## **M54 to M6 Link Road M54 - National Infrastructure Planning**

Further to my letter of 18 May 2020, registering as an Interested Party, I would like to make the following more detailed representations on behalf of my constituents:

Drawing Title
**FIGURE 2.8:
 THE SCHEME**

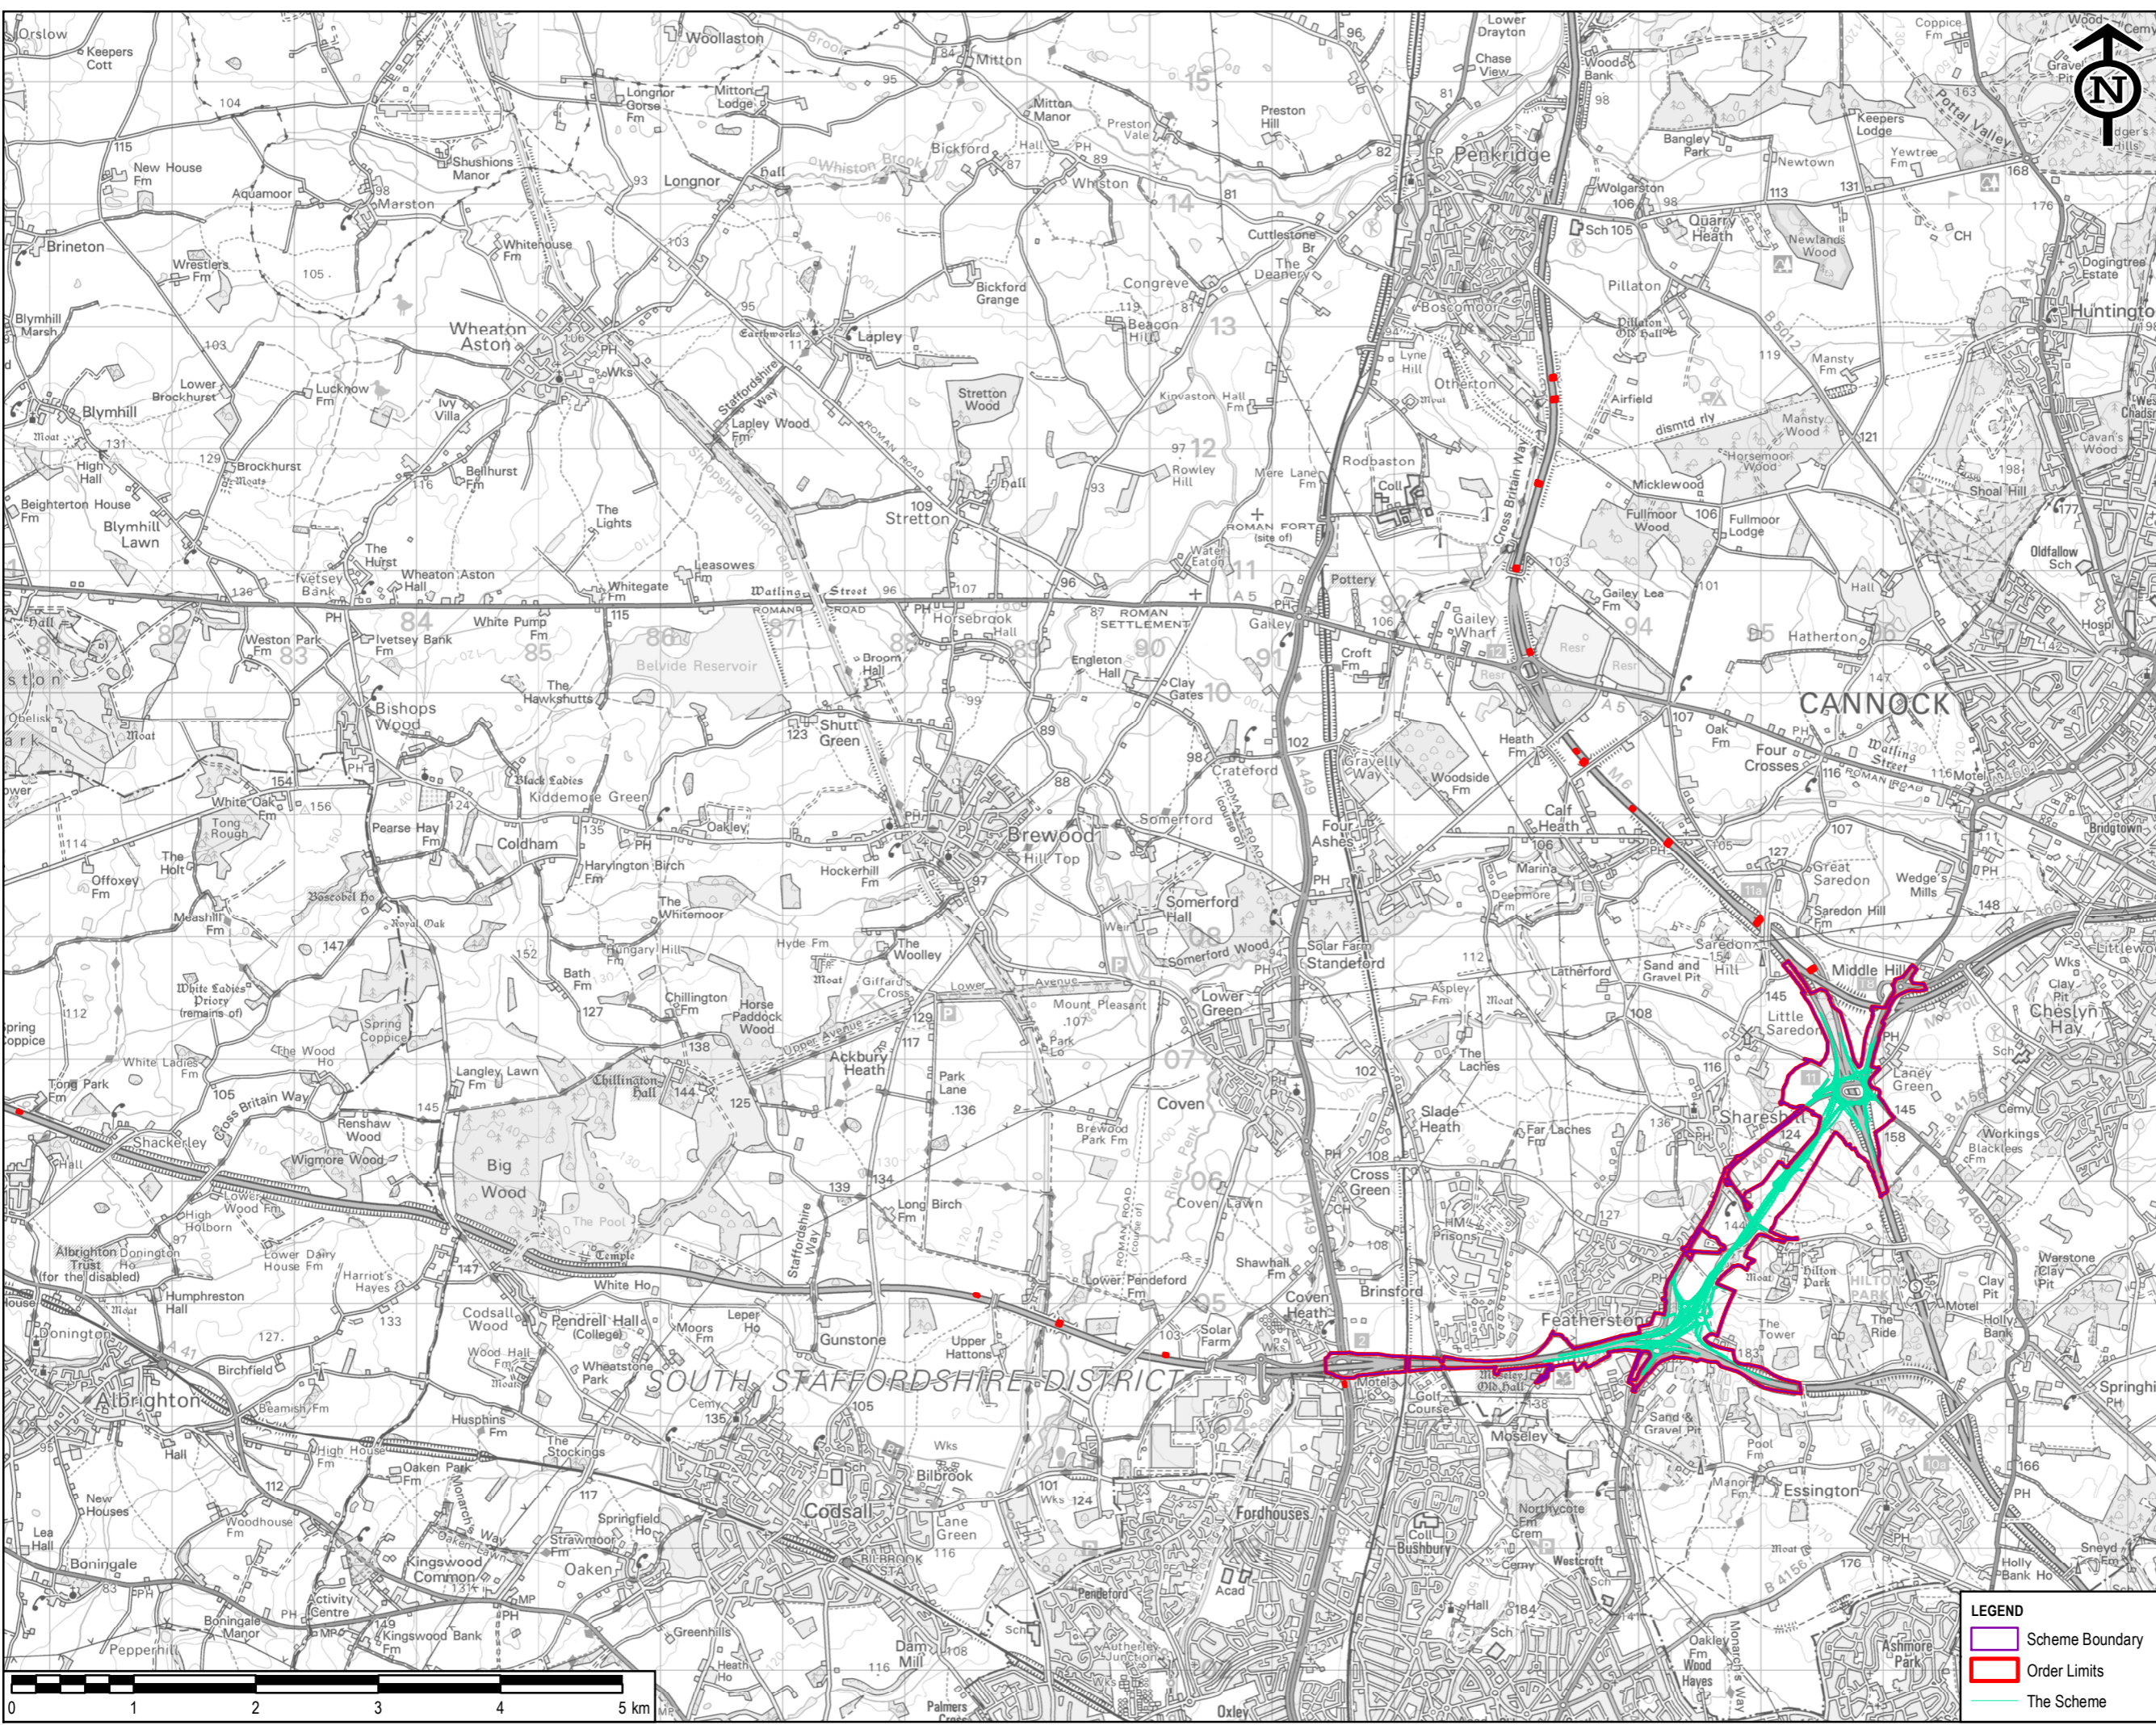
While the current scheme does achieve a main objective of diverting traffic from the existing A460 through Featherstone, all traffic will now need to pass through the Laney Green M6 junction 11, albeit it will be enlarged. I understand that passive provision has been made for a future link with the M6T, although this is not part of the current proposal. As such the current scheme may not provide the relief to the Laney Green M6 Jc11, as originally envisaged.

In addition, residents at Hilton have previously expressed concern on the proximity of the proposed road to existing elderly person residential properties at Dark Lane and are rightly concerned over noise and air pollution issues. From Highways England's visualisation flythrough video, while it appears to show some wooden fencing and tree planting on this sensitive boundary, it is not apparent that an earth bund is to be provided to provide more effective noise mitigation, which I consider should be investigated including an eastward realignment of the proposed road.

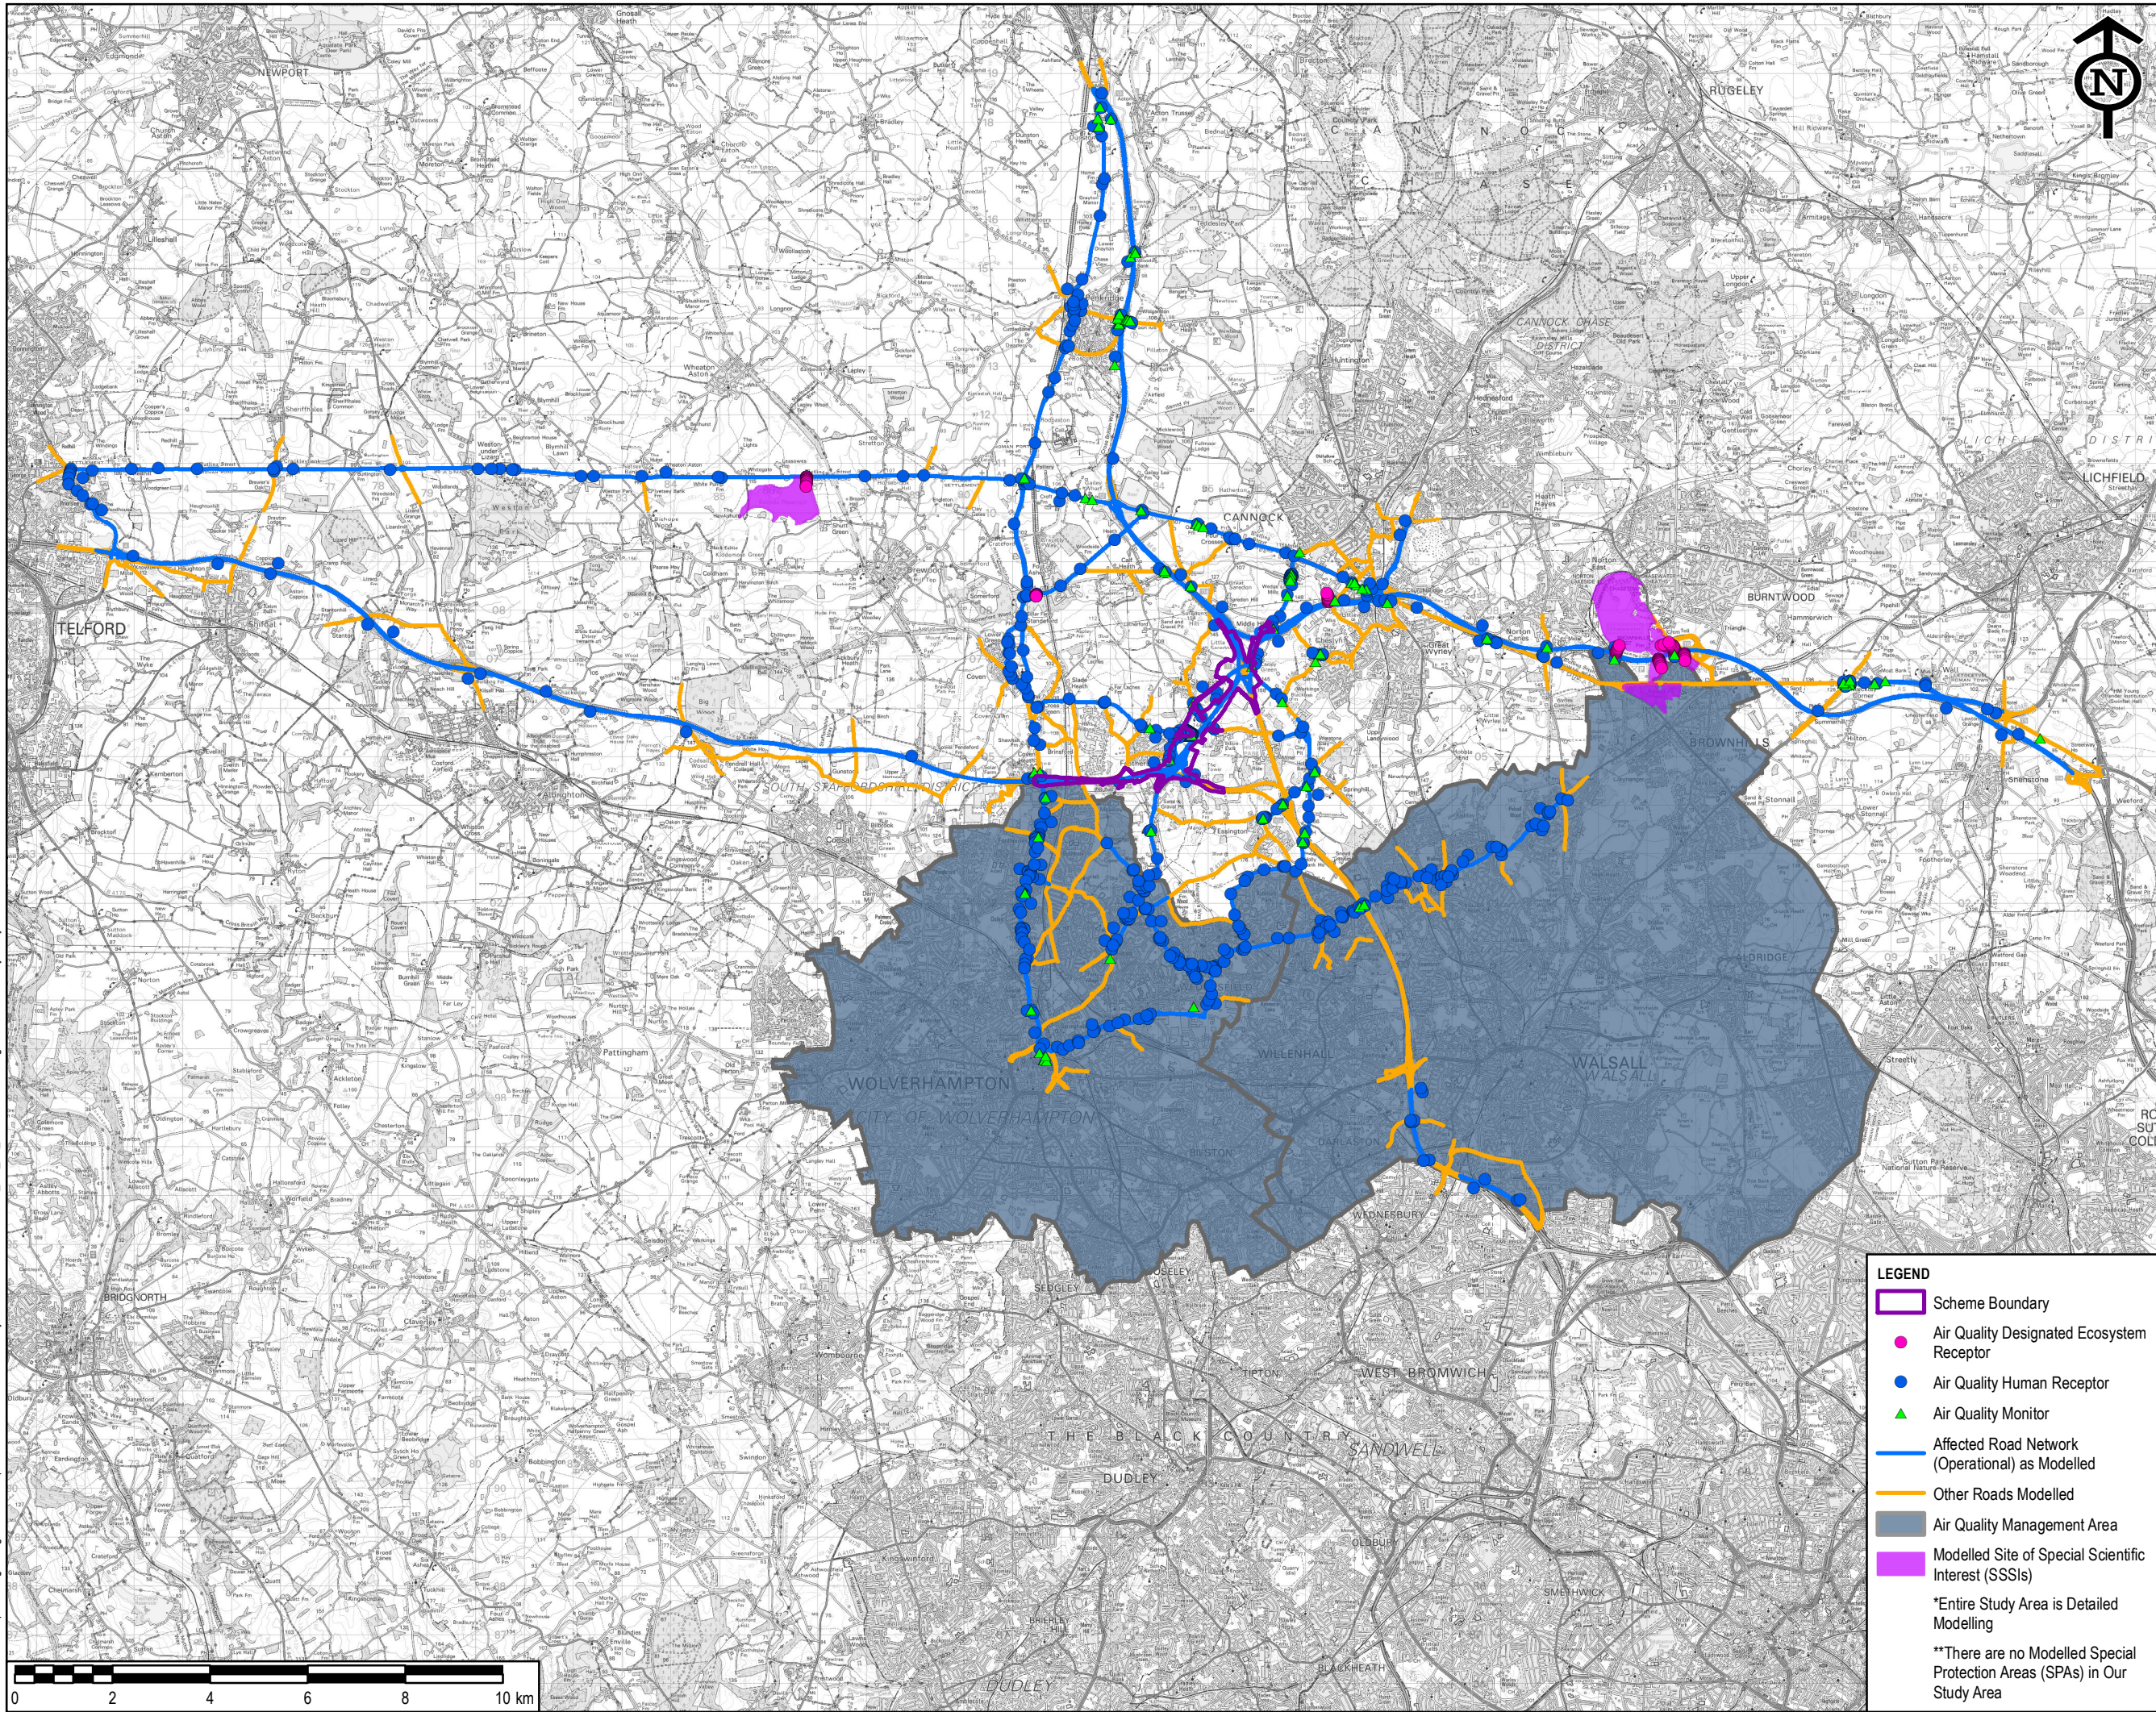
- Confirmation that an assessment has been carried out of fine particulate matter (PM2.5) with regard to transport emissions and the impact of air quality upon public health, as requested by Public Health England, in their letter of 11 February 2019, on the PINS - Scoping Opinion, February 2019.
